Our ref: 23/00041/TREECA
Please ask for: Luke Swales
Direct dial: 01553 616865
E-mail: borough.planning@west-norfolk.gov.uk

APPLICATION FOR TREE WORK

Details: **T1 Sycamore - Fully Remove and replant fruit tree nearby**
T2 Silver Birch - Partial Crown thinning and reduction of approx 1m in height at
The Cottage School Road East Rudham King's Lynn Norfolk

TREES

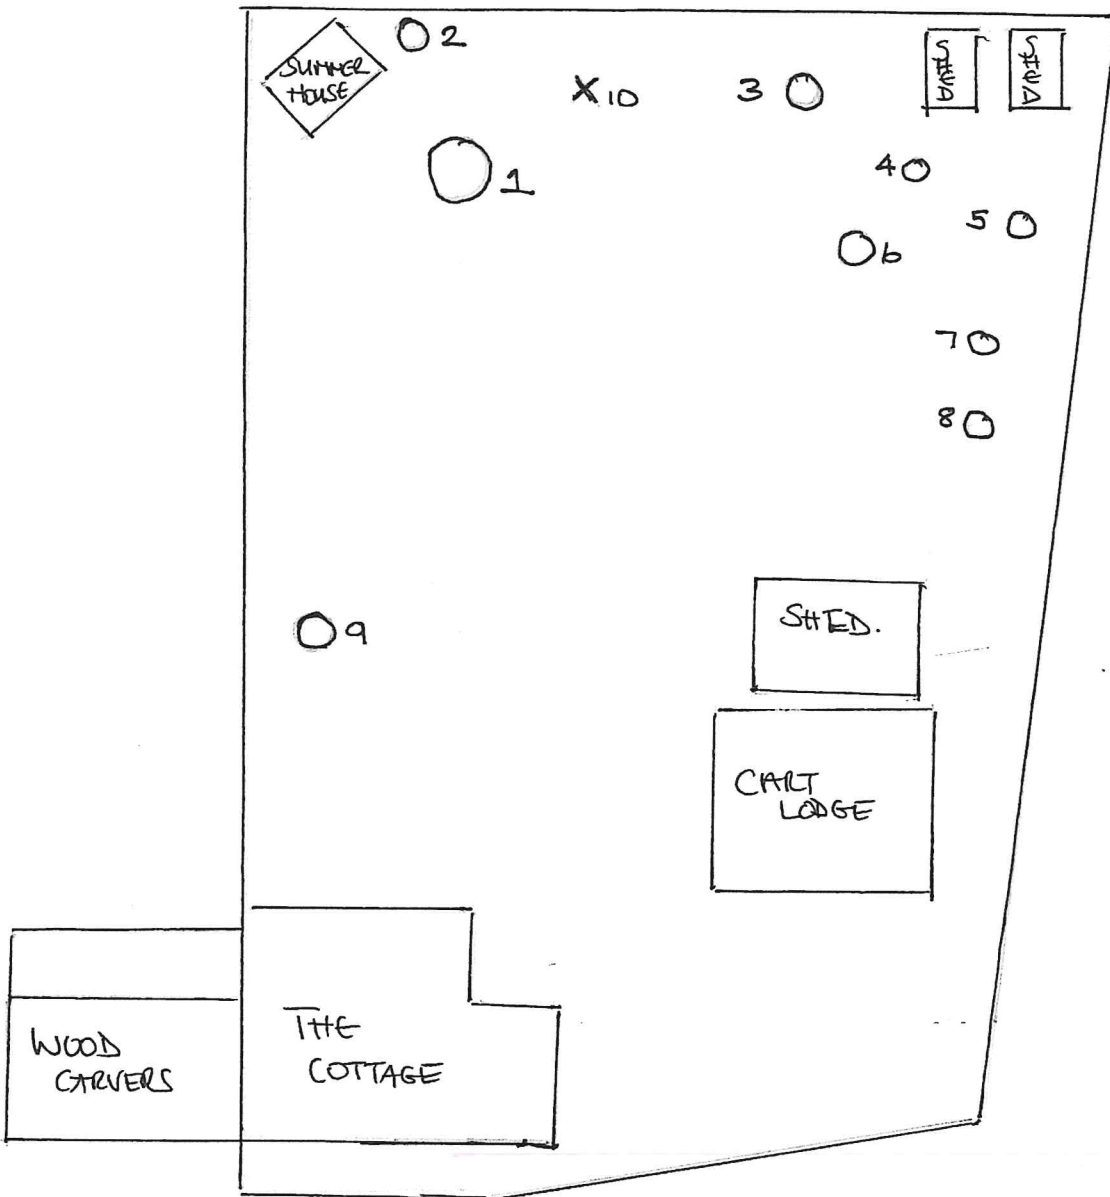
1. Please confirm whether the tree stumps are to be ground out or to remain, if the latter please confirm the finished height of the remaining stump.
2. In your application form you mention "Partial Crown thinning and reduction of approx 1m in height" however we will require some more information. Please provide the existing height of the tree as well as the new proposed height of the tree. Please also state if you will be reducing just the top of the tree or if you will be doing work to the top and sides etc.
